PLANNING AMENDMENT

H06/0575/96/1

Proposed extension
to BUNGALOW.

REVISION of TOILET &
RELINING of JAIL & NEW
WINDOW.

## Plan Proposed

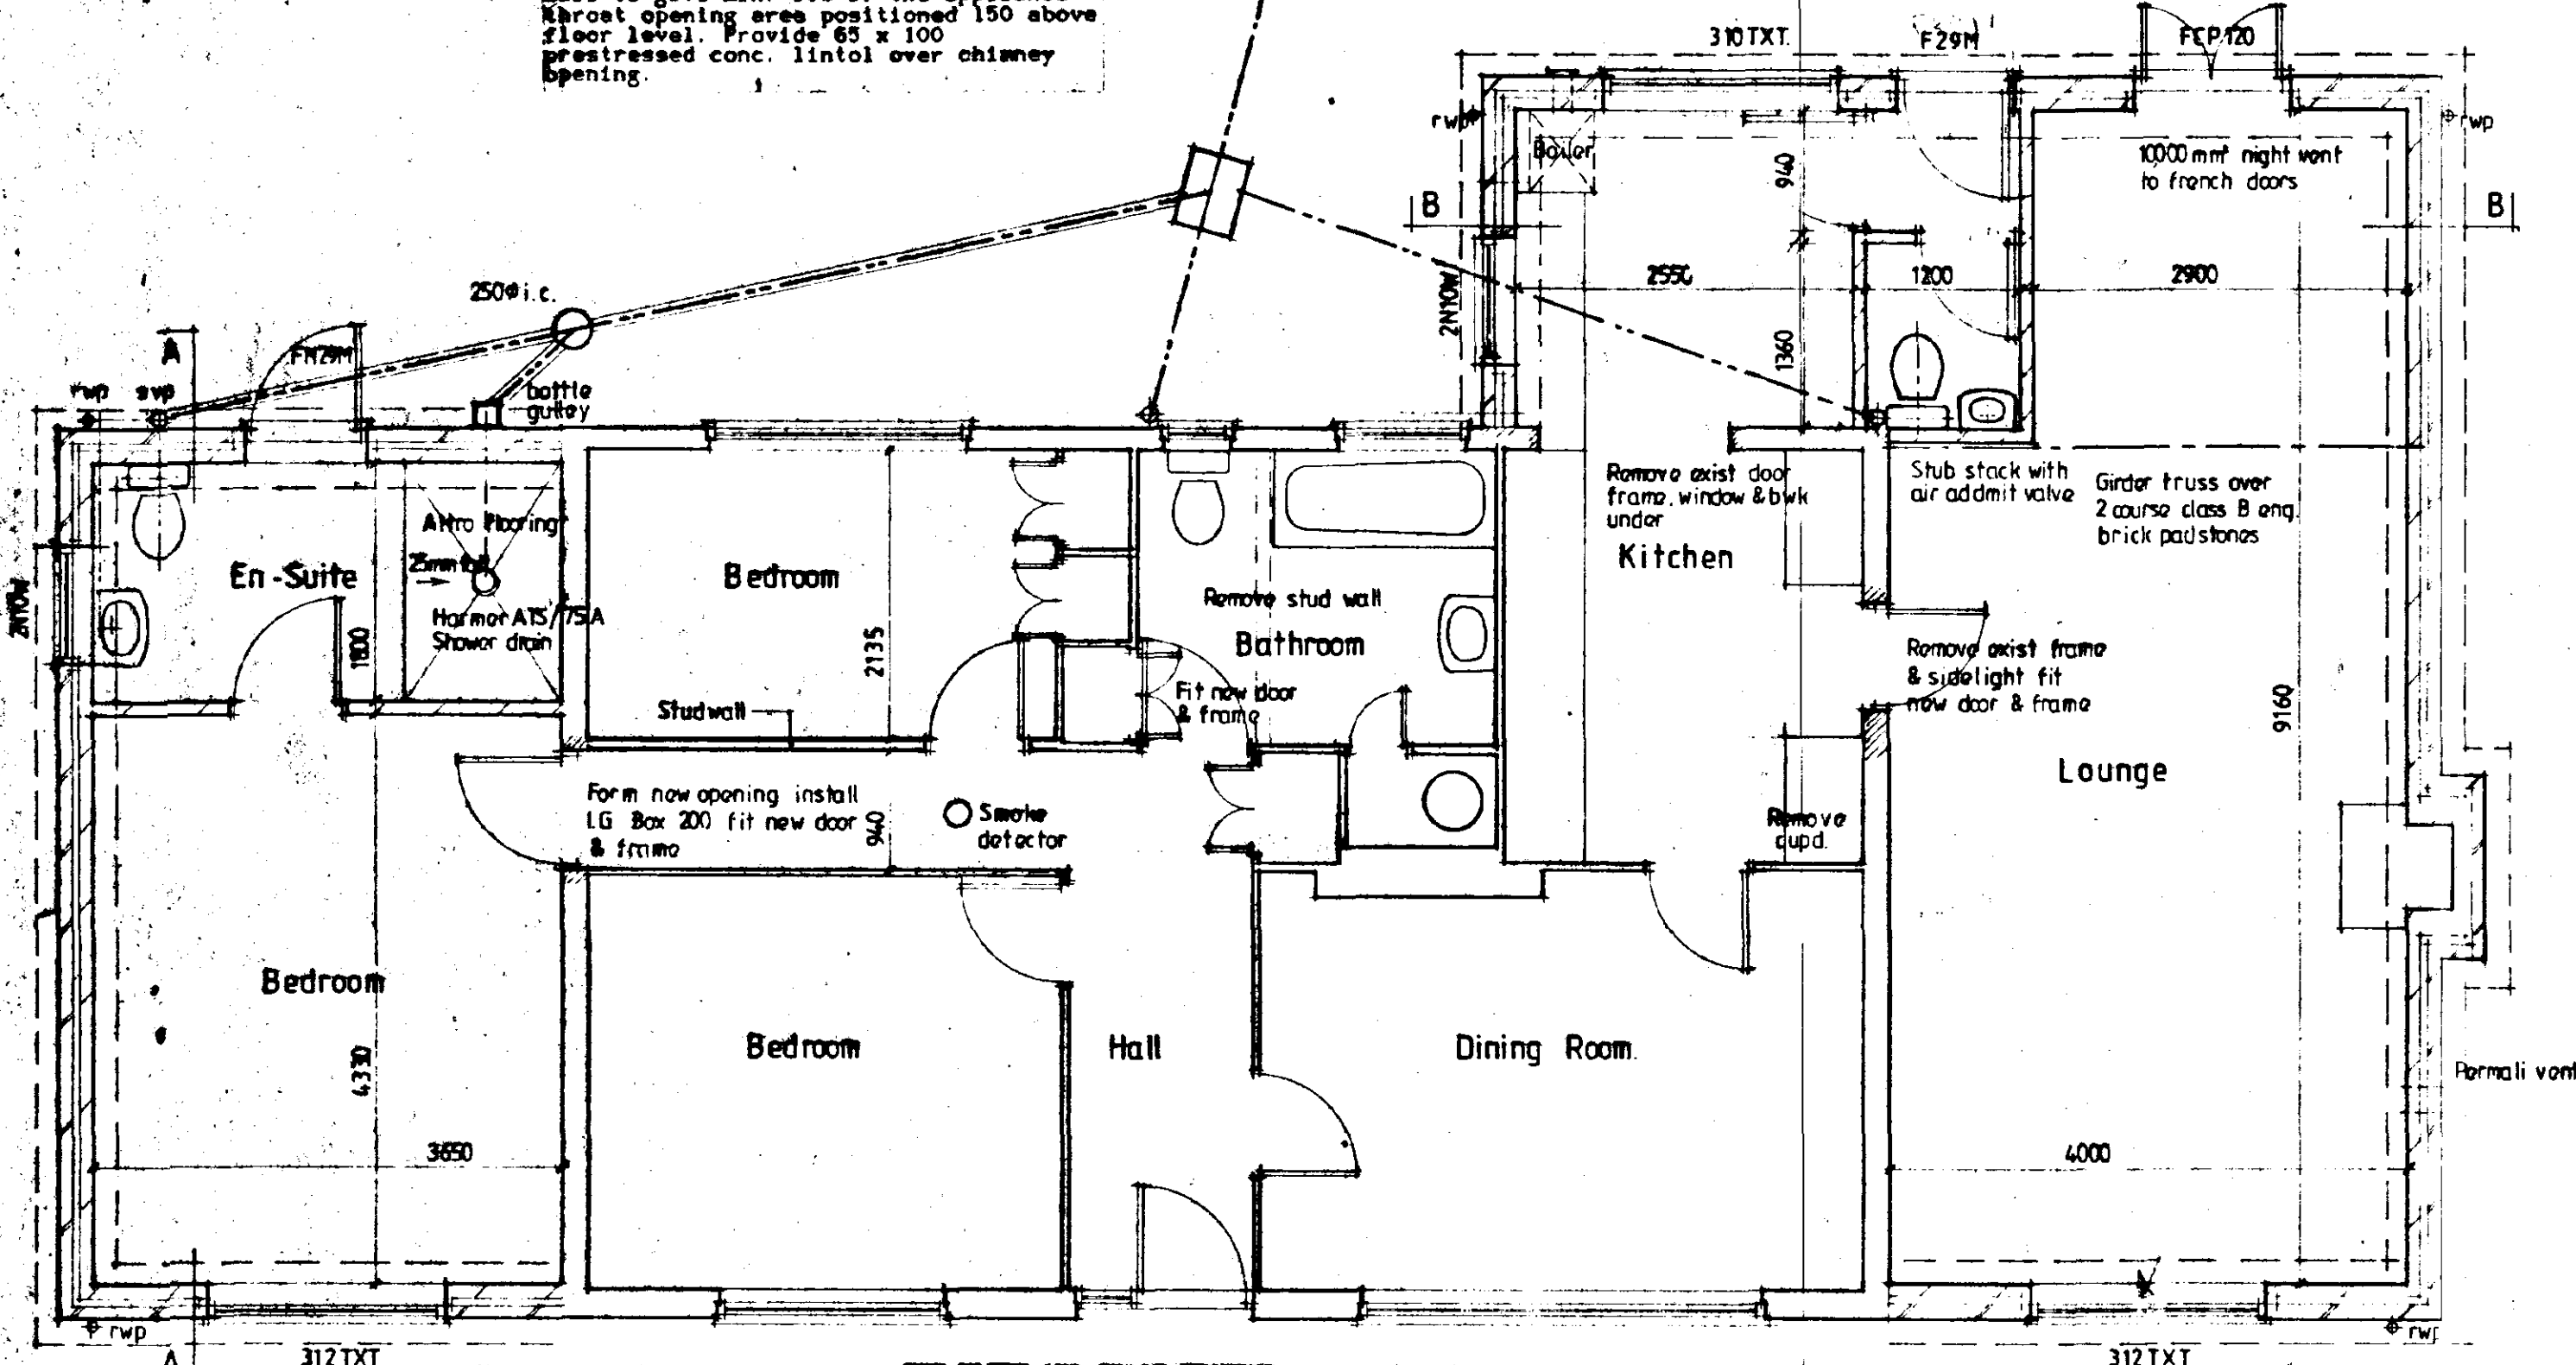
Amendment: Addition of toilet & reposition of door and new window
Drawing No. 95035

The amended details submitted in respect of the above proposal have now been considered, and I am able to inform you that there are no objections to the amendment being implemented to the extent described above.
